**RE: Response to Request for Information for SSD 5175 (Mod 4) and SDD 8588 (Mod 2)
Eastern Creek Business Hub**

Ethos Urban has prepared this letter on behalf of Frasers Property Australia in response to your letter dated 26 June 2019, and the associated submission from RMS relating to the Eastern Creek Business Hub development.

DA38 P 1

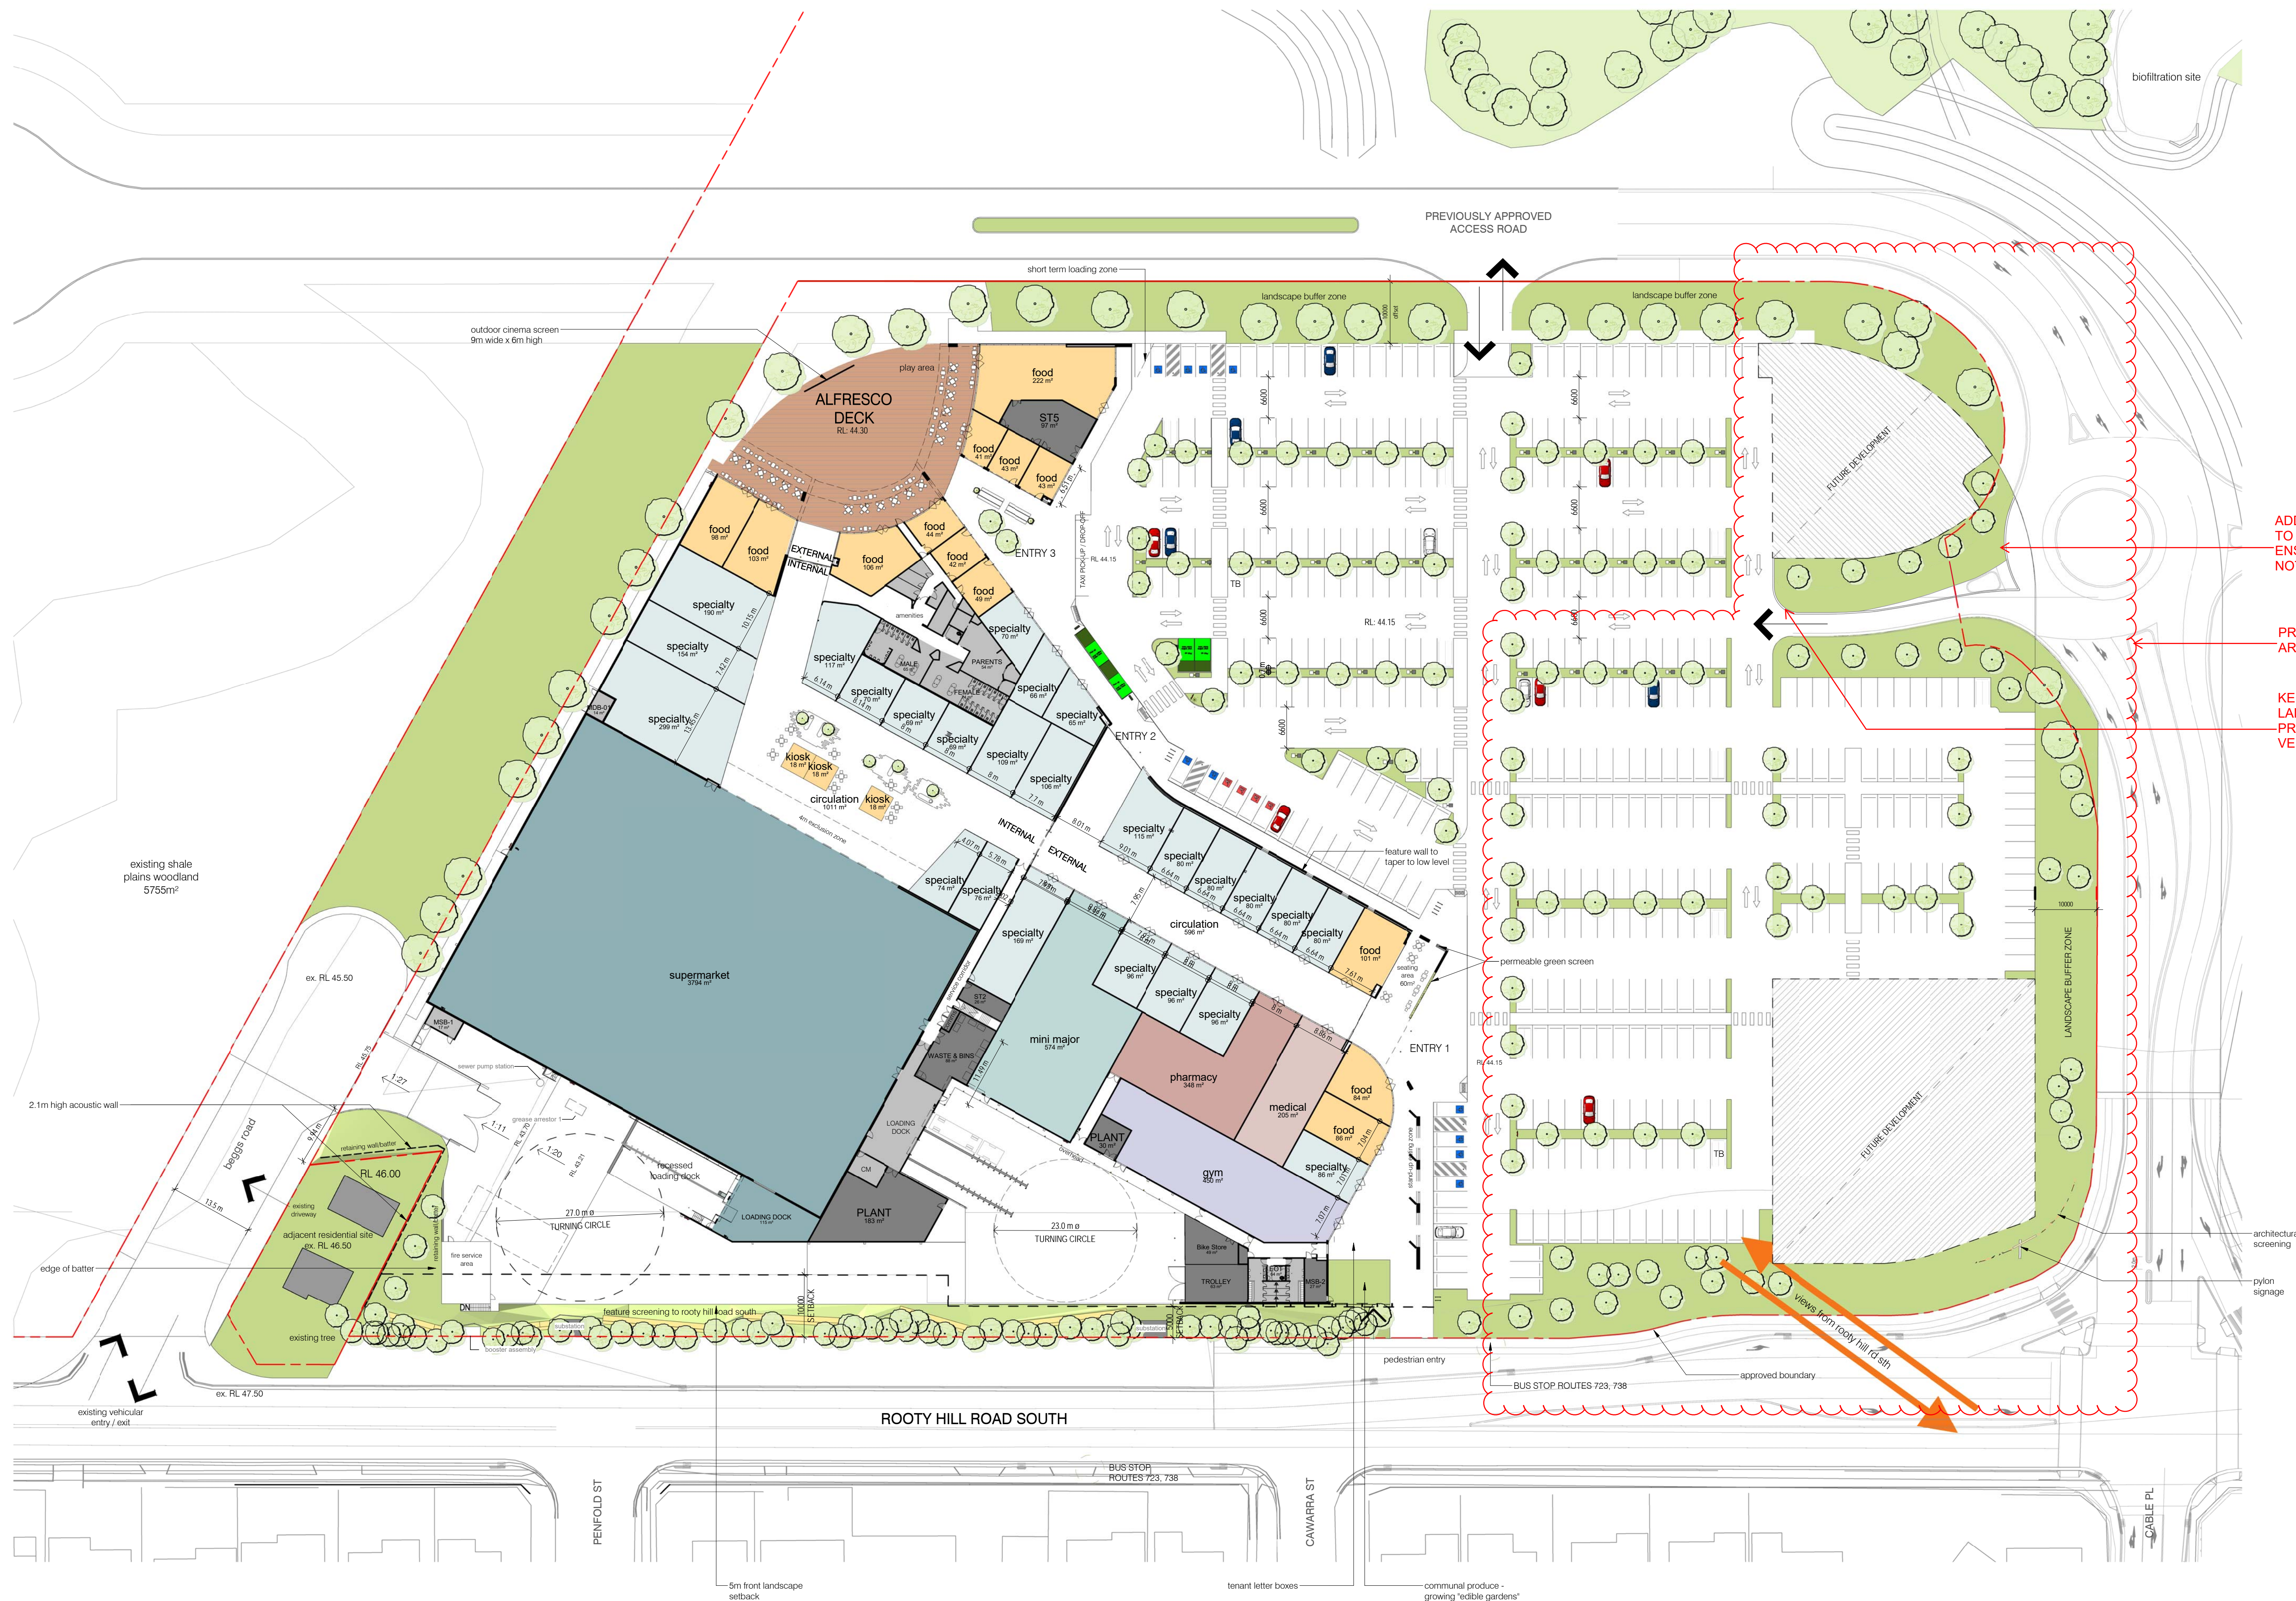
RMS has requested that access to Lot 2 from the proposed roundabout be modified from an entry/exit access to an entry only access arrangement to mitigate concerns that the roundabout may impact the operation of the Rooty Hill Road South / Cable Place intersection. Whilst the entry/exit access arrangement is still preferred and our analysis demonstrates no fundamental impacts, Frasers has amended the Concept Plans (SSD 5175) and detailed design plans (SSD 8588) (refer to **Attachment A**) to satisfy the RMS request. A traffic statement has also been prepared to address the suitability of the revised access arrangements into Lot 2 and has concluded that the proposed amendments will not detrimentally impact internal vehicular movements (**Attachment B**).

The revised access arrangement will also require the Civil Works Plans prepared by Henry & Hymas to be amended. Accordingly, it is proposed to include the following condition under Schedule 3 of the Concept Plan consent (SSD 5175):

Prior to the issue of a CC relevant to the construction of the roundabout, the applicant shall submit to the satisfaction of the Certifying Authority amended civil works plans reflecting the entry only access arrangements for Lot 2 of the Concept Plan.
